PEERLESS SUBDIVISION

A PORTION OF THE NORTHWEST QUARTER OF SECTION 13, TOWNSHIP 13 SOUTH, RANGE 64 WEST OF THE 6TH P.M. COUNTY OF EL PASO, STATE OF COLORADO

FINAL PLAT

FINAL PLAT

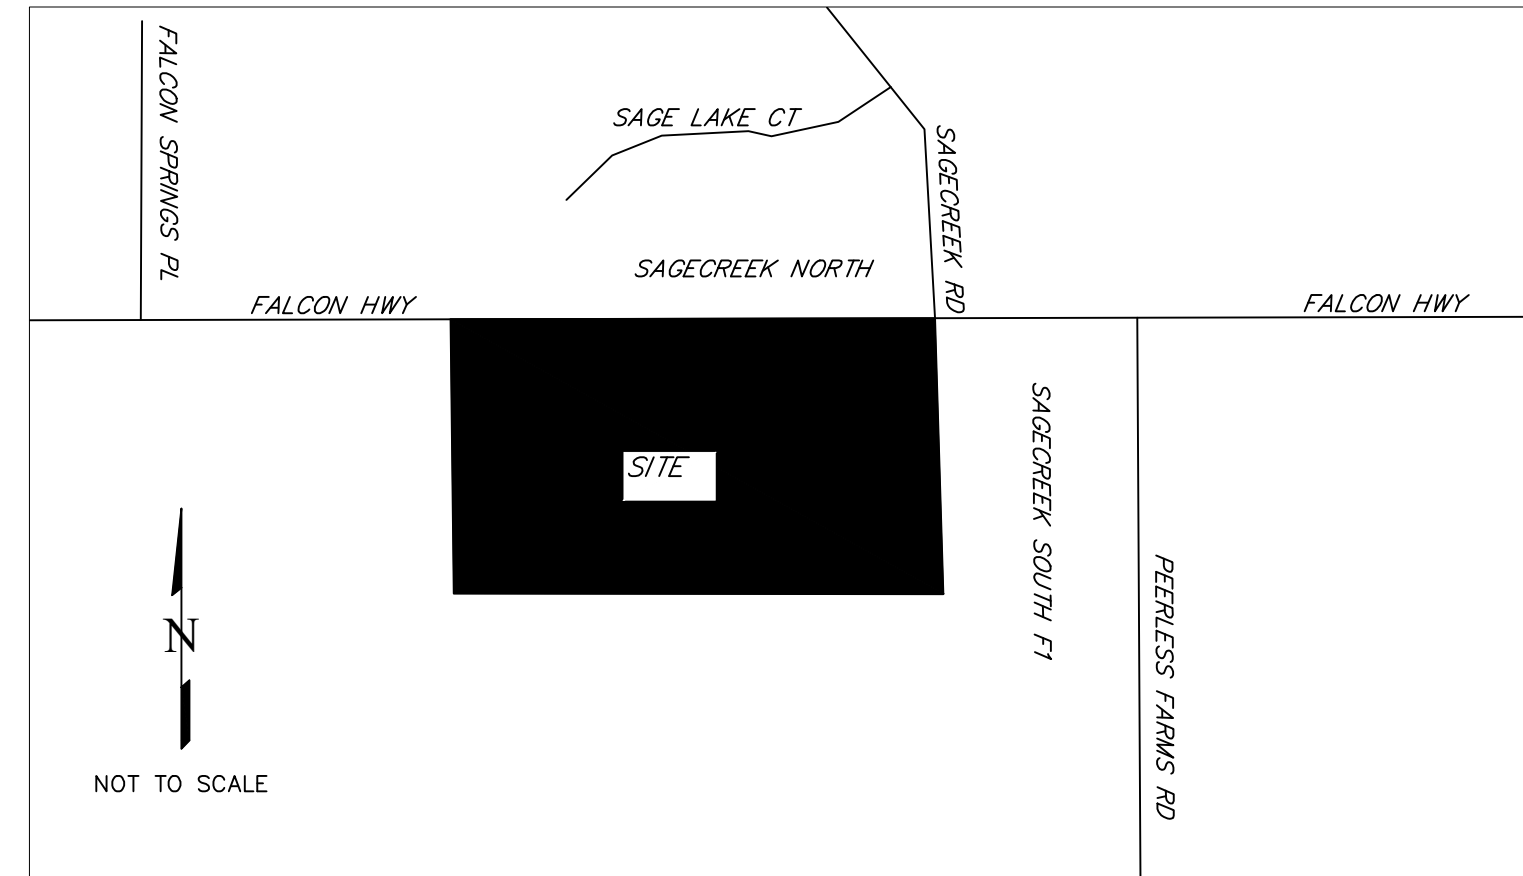
Please address all V1 comments

- ALL REFERENCES TO RECEPTION NUMBERS SHOWN HEREON ARE PUBLIC DOCUMENTS RECORDED WITH THE CLERK AND RECORDER. **V1 comments on the General Notes section remain unaddressed.**

Unresolved: Provide Summary Table

Unresolved from Submittal 1:
 On the submitted PBMP form, Exclusion E "Large Lot Single Family Sites" was selected to exclude the site from a PBMP. The qualifications for this exclusions is presented in the ECM section I.7.1.B.5:

"Large Lot Single Family Sites. A single-family residential lot, or agricultural zoned lands, greater than or equal to 2.5 acres in size per dwelling and having a total lot impervious area of less than 10 percent. A total lot imperviousness greater than 10 percent is allowed when a study specific to the watershed and/or MS4 shows that expected soil and vegetation conditions are suitable for infiltration/filtration of the WQCV for a typical site, and the permittee accepts such study as applicable within its MS4 boundaries. The maximum total lot impervious covered under this exclusion shall be 20 percent."

Add a note to the plat acknowledging that per ECM Section I.7.1.B.5, the residential lots impervious area may not exceed 10 percent unless a study is prepared in compliance with the requirements laid out in the above ECM Section and the impervious area may not exceed 20 percent. This impervious area for each lot must include the proposed driveway.
